# CITY OF ALBUQUERQUE

May 5, 2021

**Re: Children's Grief Center  
4125 Carlisle Blvd NE  
Traffic Circulation Layout  
Architect's Stamp 04-13-2021 (G16-D157)**

B1 SITE PLAN
1" = 20'-0"

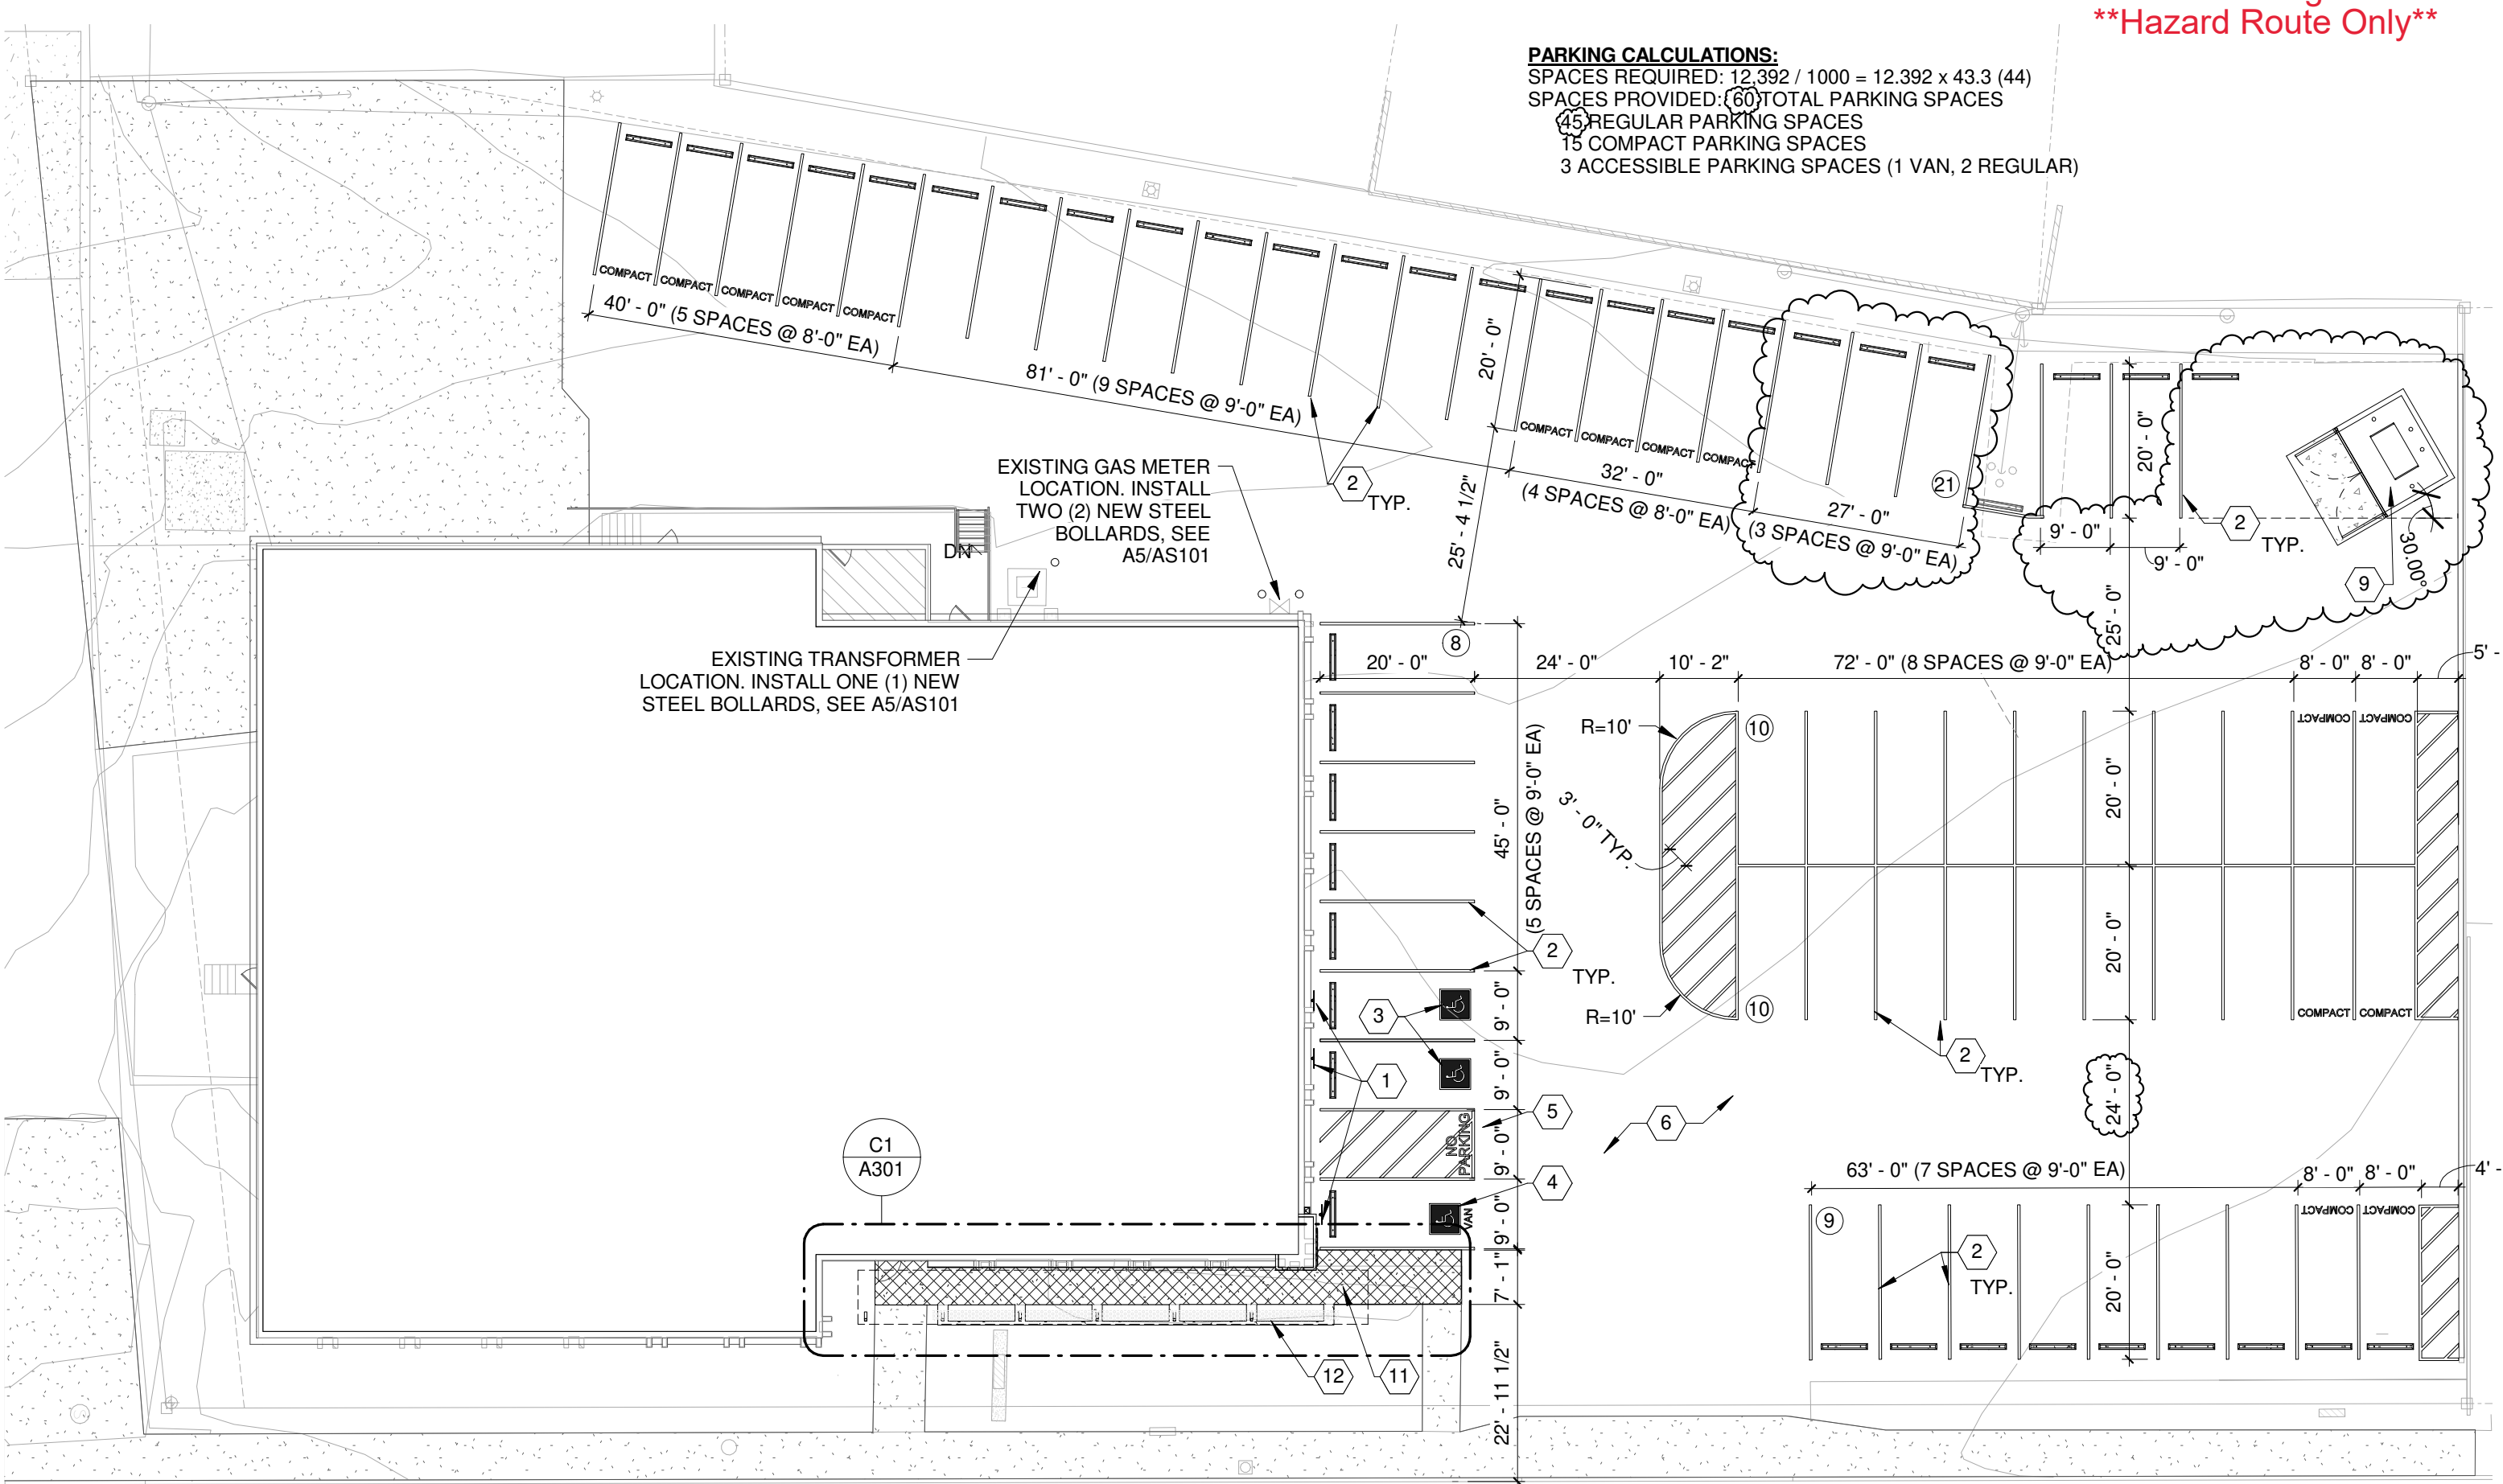
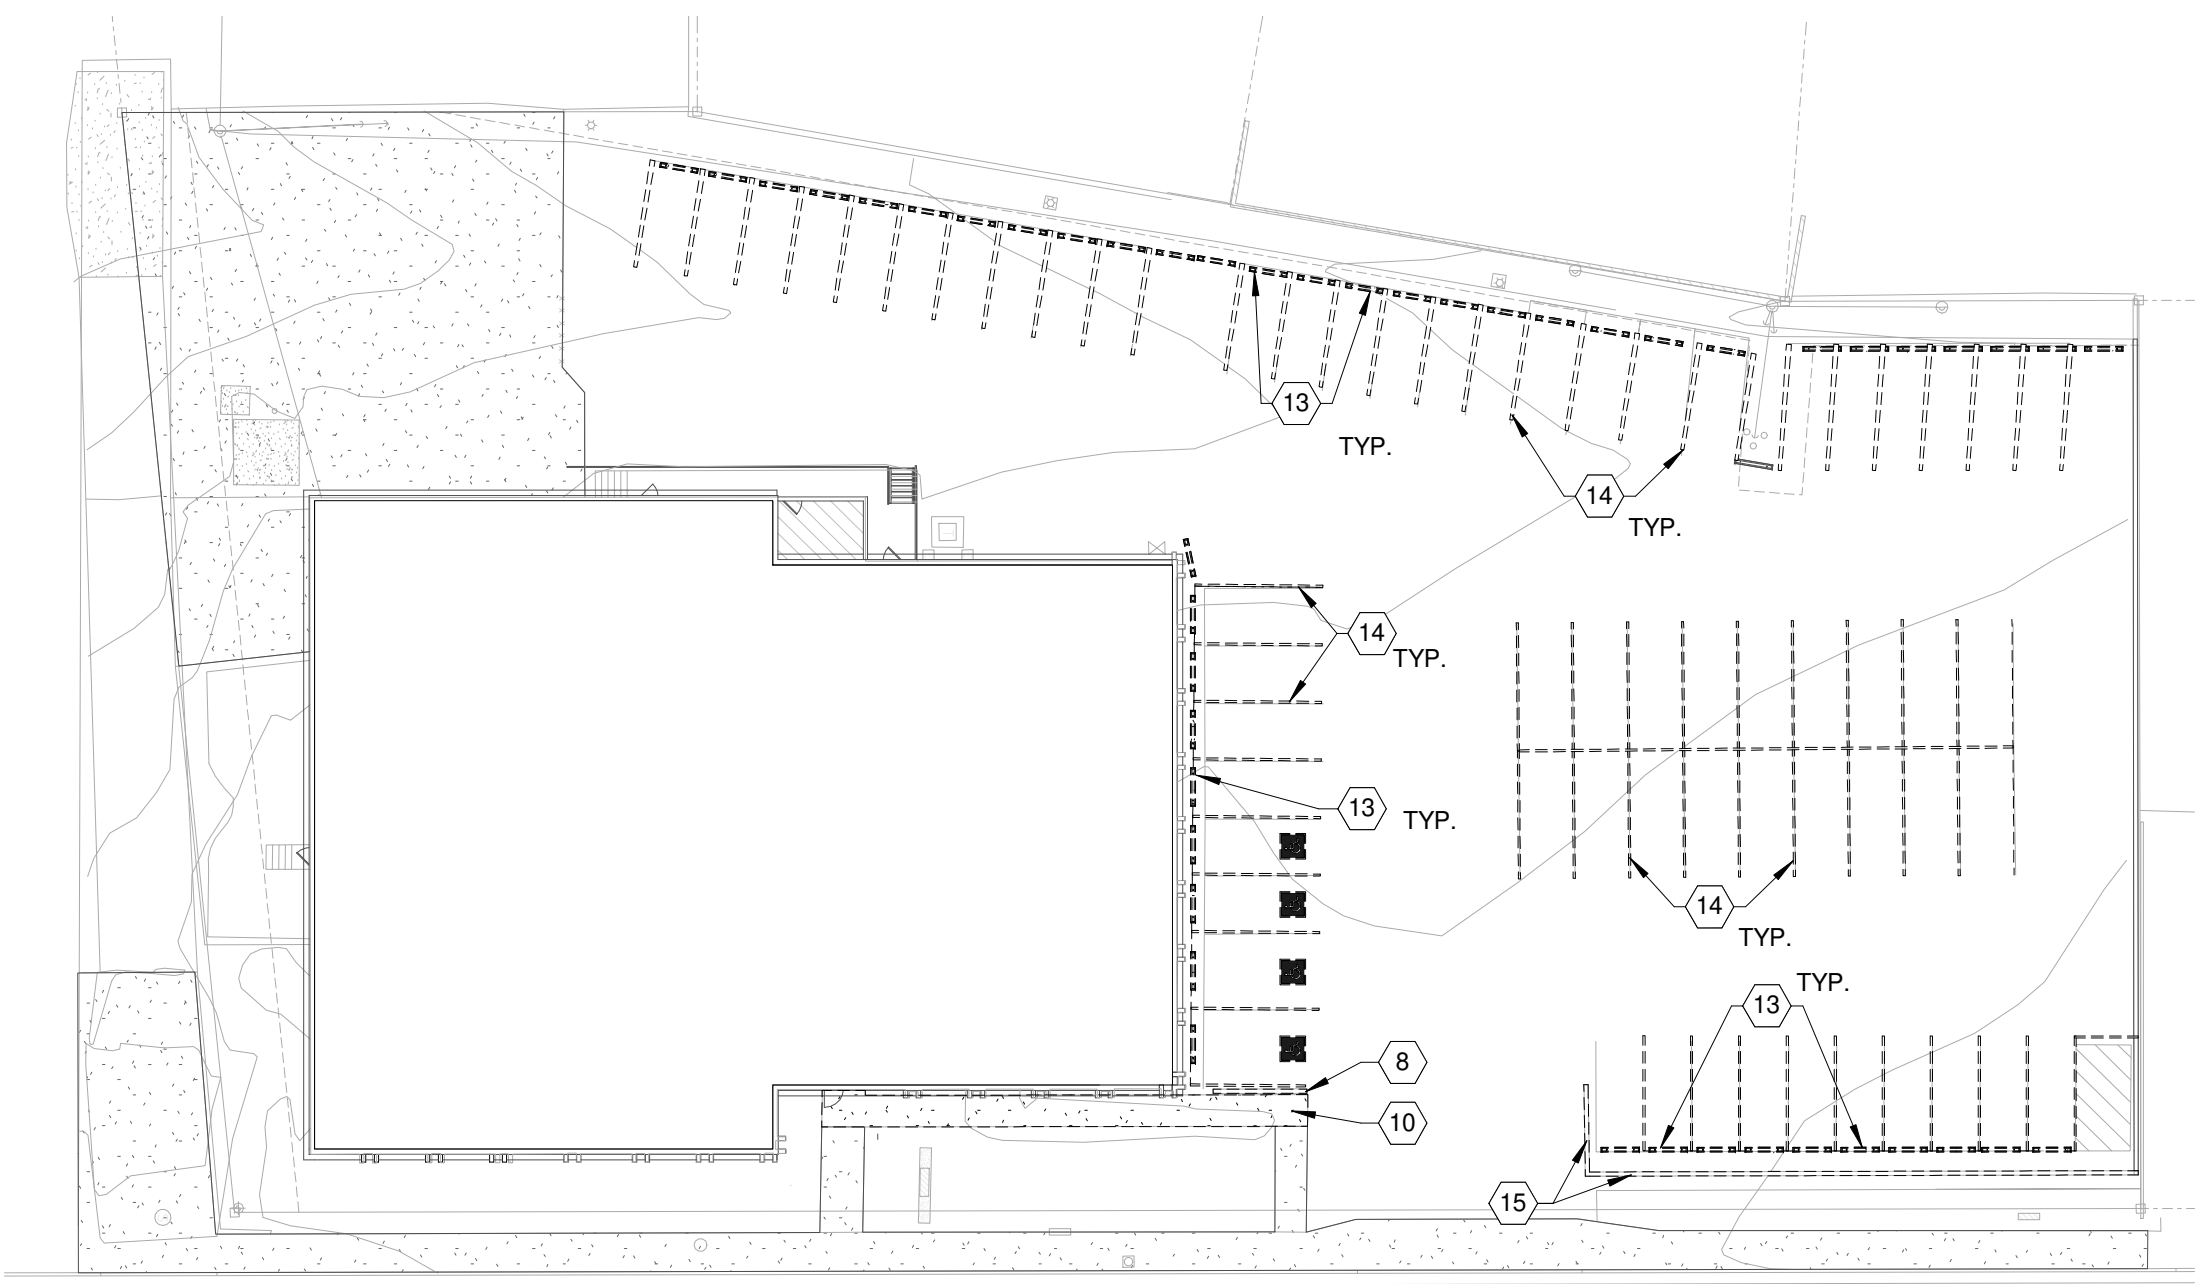
3. **Please identify all existing** buildings, **doors**, structures, sidewalks, curbs, **drive pads, wall** and **anything** that influences the parking and circulation on the site.

4. Identify all existing access easements, **property line** and rights of way width dimensions.
5. **Identify the right of way width, medians, curb cuts, and street widths on Carlisle Blvd NE.**

6. Clarify **existing property lines** and proposed property lines. Verify through out parking lot.
7. Provide drive aisle width between stairs and parking stall end stripe as well as bollards and end stripe ( West side of building).

8. Minimum drive aisle is 22 ft for two way traffic.
9. Bollards: Paint all bollards yellow (add note).
10. Key Note 9: You are referencing the wrong the detail for this note. Should this detail read B3/AS101?

11. Key Note 3: You are referencing the wrong the detail for this note. Detail C5/AS101 will be appropriate for this key note?
12. Last parking stall fronting building (west end): You will need to protect this parking stall from any vehicle turning movements around the building.

13. A **5 ft keyway** is required for dead-end parking aisles.
14. Maximum access width for arterial, collector, and local streets are as follows:

15. Carlisle Blvd Entrance: **Provide existing entrance/driveway width.**
16. The minimum parking stall dimensions are:

17. **Motorcycle parking spaces** shall be designated by its own conspicuously posted upright sign, either free-standing or wall mounted per the zoning code. **Label pavement MC.**

22. List radii for all curves shown; for passenger vehicles. **Radius for delivery trucks, fire trucks, etc. is 25 ft. or larger. Minimum drive aisle width is 20 ft.** Fire approval will be needed for propped parking lot circulation.

23. Per the IDO, a 6 ft. wide ADA accessible pedestrian pathway is required from the public sidewalk to the building entrances. **Please clearly show this pathway and provide details.**

24. Per DPM, a 6 ft. wide ADA accessible pedestrian pathway is required from the ADA parking stall access aisles to the building entrances. **Please clearly show this pathway and provide details.**

26. Solid Waste: Provide a copy of refuse approval.
27. Please provide a sight distance exhibit at existing driveway fronting Carlisle Blvd.
28. Show the clear sight triangle and add the following note to the plan: "Landscaping and signage will not interfere with clear sight requirements. Therefore, signs, walls, trees, and shrubbery between 3 and 8 feet tall (as measured from the gutter pan) will not be acceptable in the clear sight triangle.

29. Please specify the City Standard Drawing Number when applicable.
30. **Shared Site access:** driveway (**southern portion of access from existing channel driveway off Carlisle**) that straddle property lines, or are entirely on one property but are to be used by another property, shall have an access easement. **Please include a copy of your shared access agreement with the adjacent property owner.**

31. Provide existing sidewalk widths fronting Carlisle Blvd.
32. Add a note stating "**All broken or cracked sidewalk must be replaced with sidewalk and curb & gutter.**" A build note must be provided referring to the appropriate City Standard drawing.
